Application for Removal or Variation of a Condition following Grant of Planning Permission or Listed Building Consent

Erection of a single storey rear and 2 storey side extensions, conversion of garage, replacement windows and external doors, rainwater goods and external landscaping.

21/0940/HOUS

UKSD's - Response to planning for Simon Forshaw

Rev	Date	Description	By	Chk'd
01		MR & MRS FORSHAW		
Project: 4 Melville Close, Branston, Lincoln, LN4 1UB				
Drawing Title: PROPOSED PLANS, ELEVATIONS				
Scale: 1:100 @ A1		Date: MARCH 2024		
Job No: 1689	Drawing No: UKSD-SA-08-0002	Revision No: A.00(a)

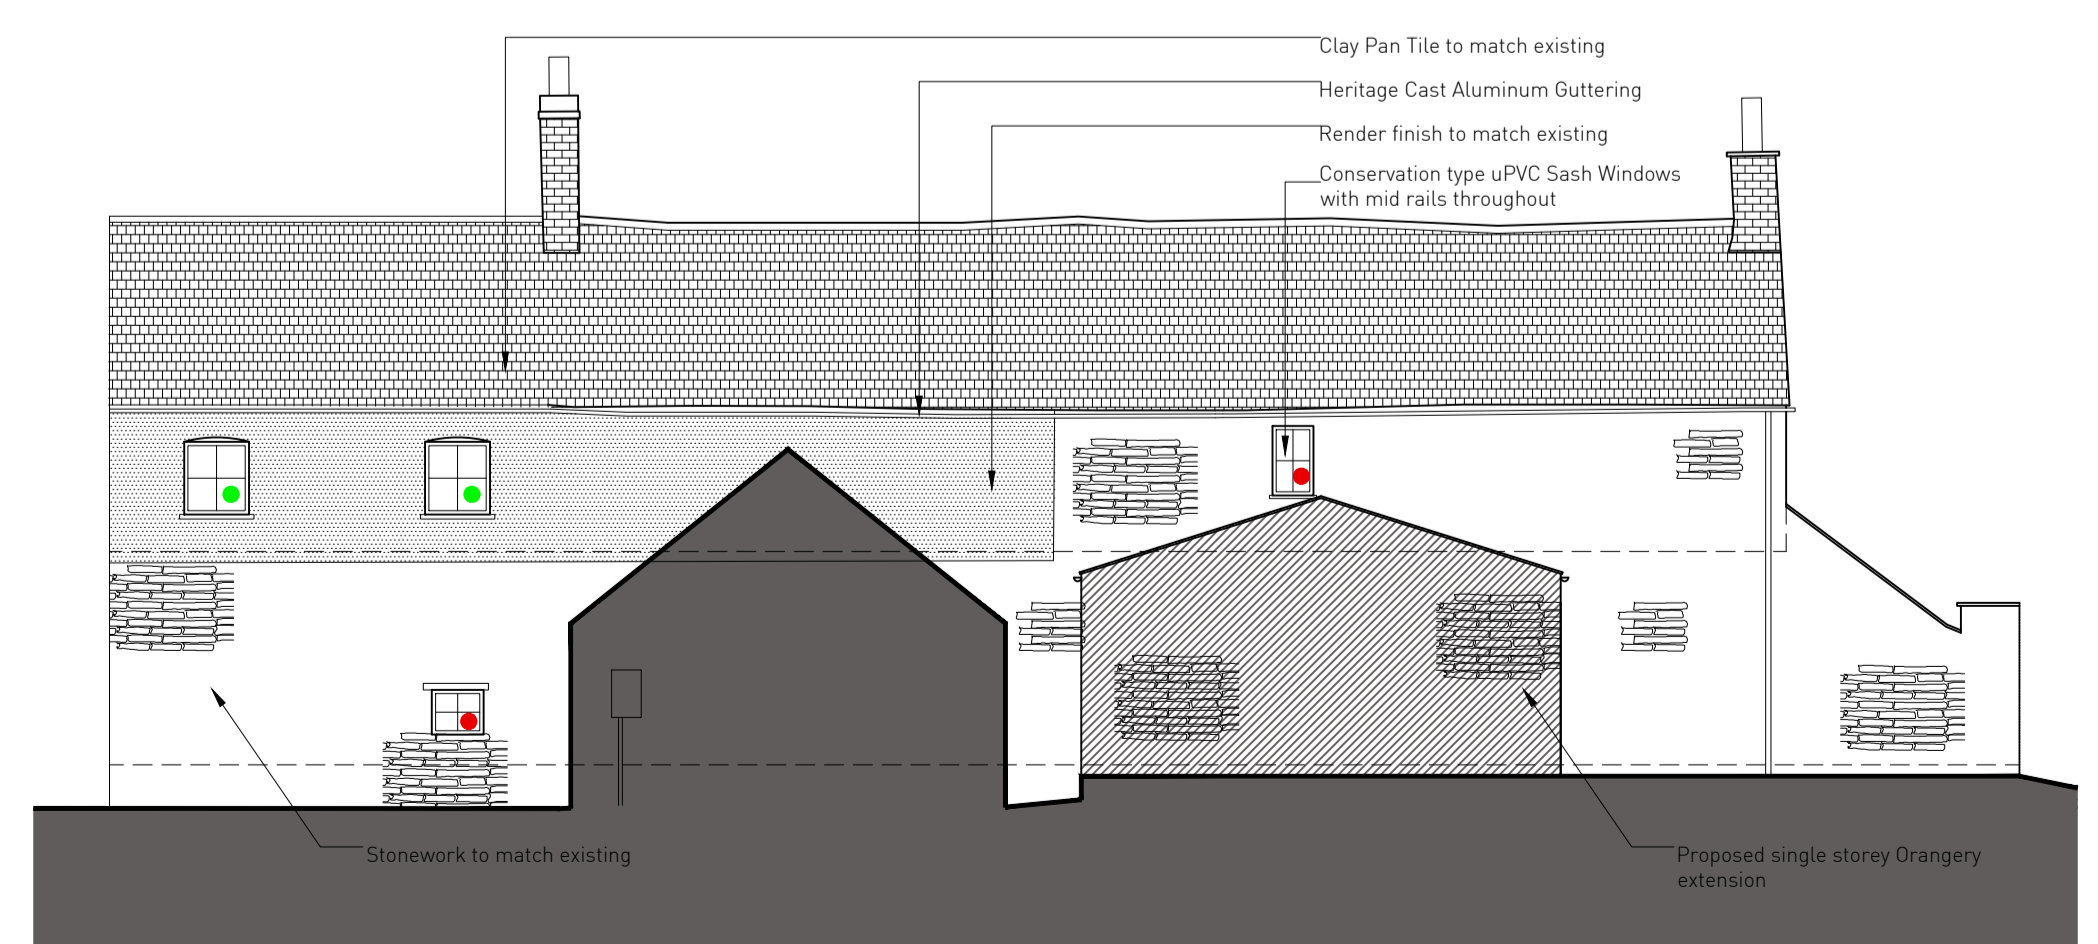
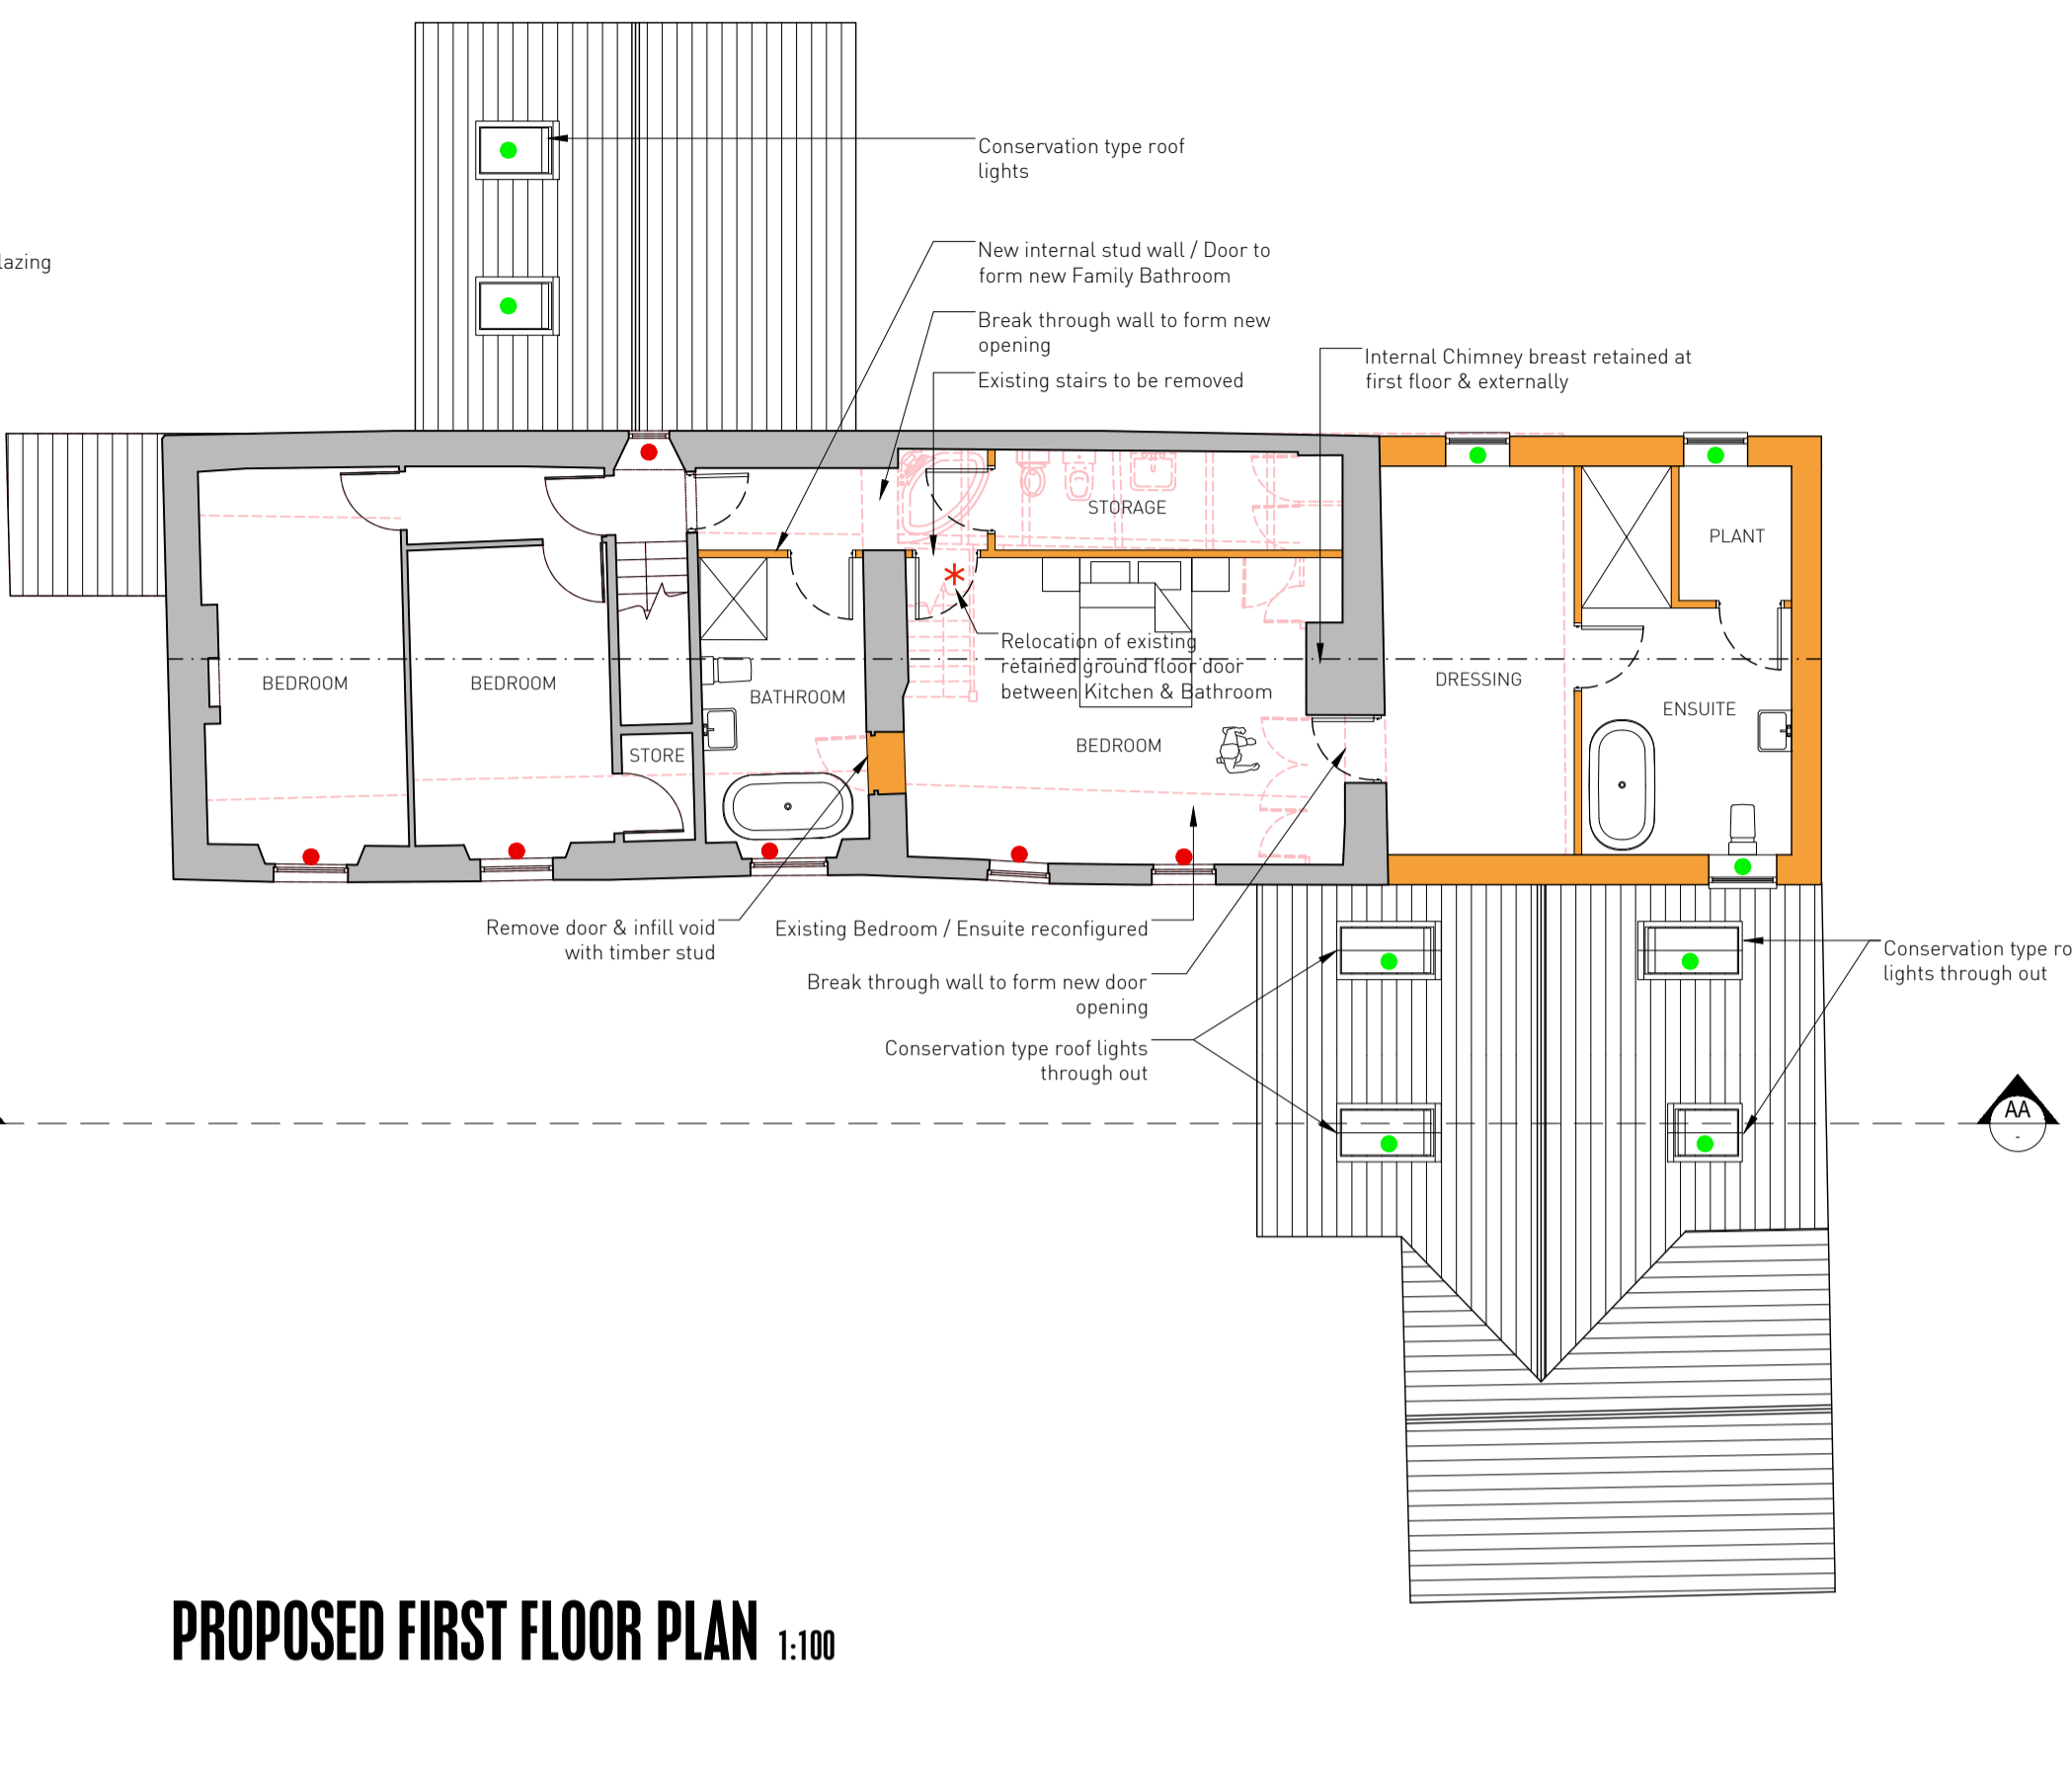
A 1st floor window on rear elevation, not shown on the approved plans, has been installed.

The faux garage doors have not been installed; instead, the apertures have been partially infilled with the intention of windows being installed in their place contrary to the approved plans. Refer to amended drawings.

The external windows and roof lights of the orangery are not in accordance with the approved plans. Drawings show 5 windows and 5 connected roof lights above. The development was found to have 4 windows and 2 separate conservation-type roof lights. Refer to amended drawings.

The roof line of the garage and front connecting single-storey extension are not in accordance with the approved plans. From inspecting the plans and consulting a resident joiner, it is clear that due to the different roof pitches, the valleys will not marry up and the plans cannot be built out correctly. This statement is supported by what has been seen as built on-site. Refer to amended drawings.

Whilst on site, I was unable to locate the sole cast iron hopper. I assume this is to be reinstalled once 'redecorated' or was obscured by scaffolding. This has not been installed yet, a temporary downpipe is in place while there is scaffolding in the way.

The window in question is indicated on the approved drawings.
